Drafted 25 April 2012

**Planning Application, Ribble Valley District
3/12/0314 Whalley Wine Shop, 63 King Street, Whalley**

Public Realm, Ribble Valley
LCC Environmental Services East
01254 828060

LOCATION OF BARRELS (Tables)
OUTSIDE SHOP

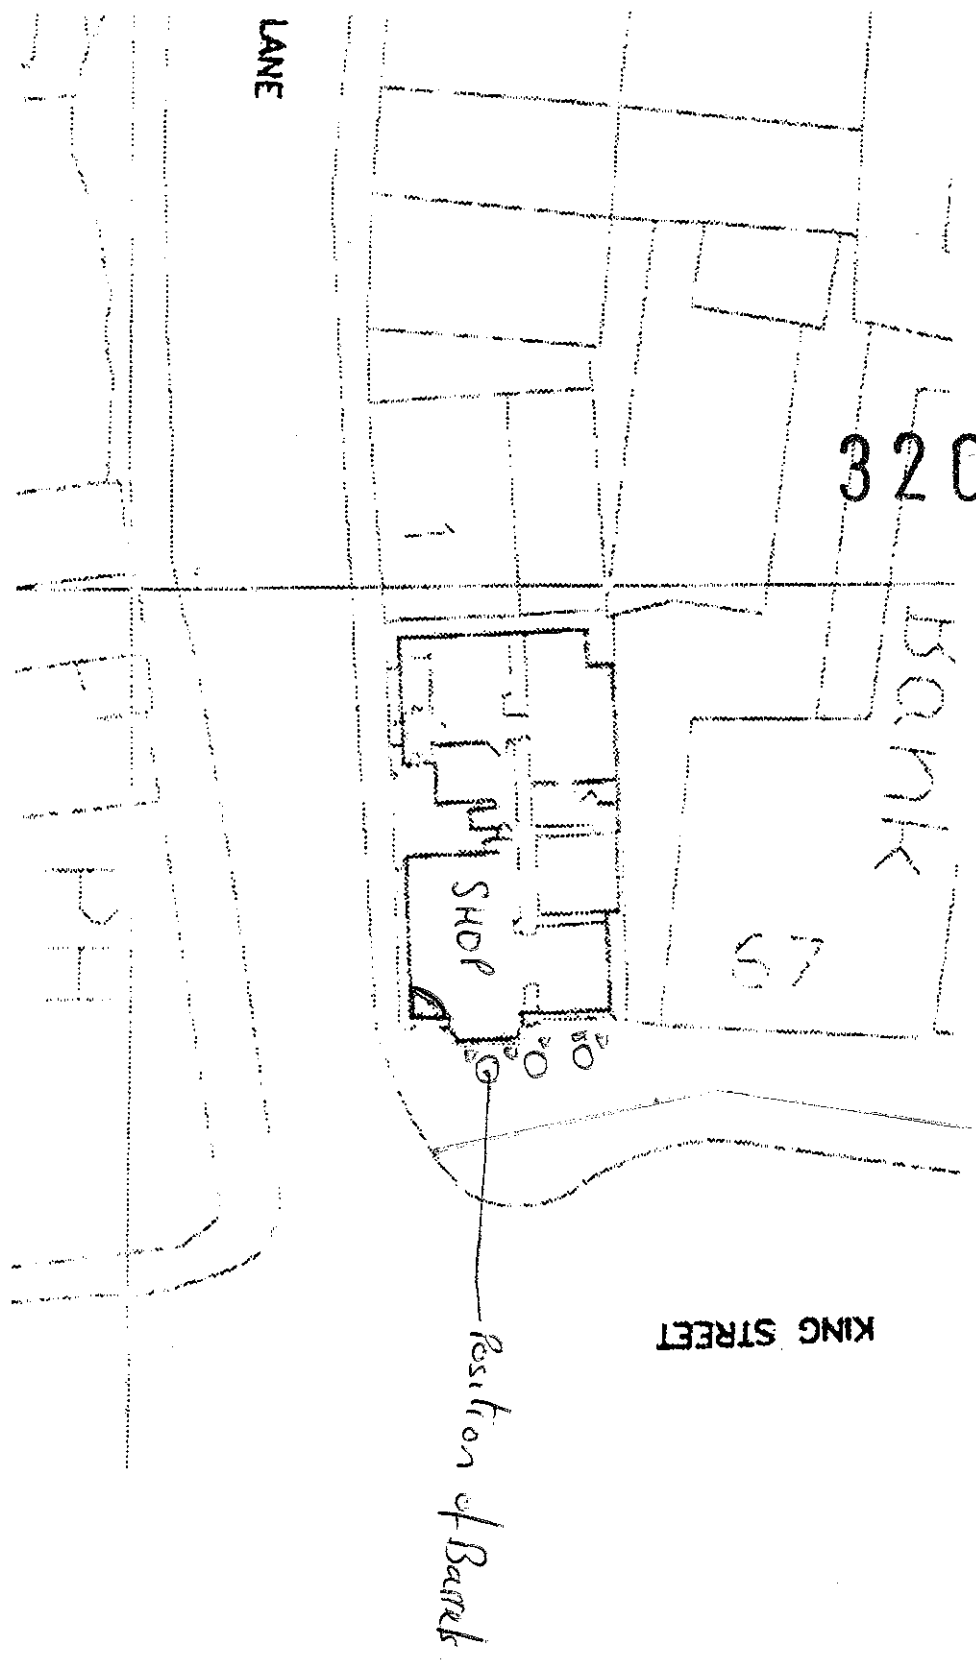
1. Will the barrels be sited discretely in the recessed area of the shop front, or will one or more barrels be placed across the bay window? My concern here is that this new activity remains off of the footway and does not cause an obstruction to pedestrians.
2. As these are full-sized barrels, approximately 95cm in height, will they be above the height of the window sills? The Applicant has noted that significant improvements have been made to the frontage, including being "enhanced with new wooden windows".
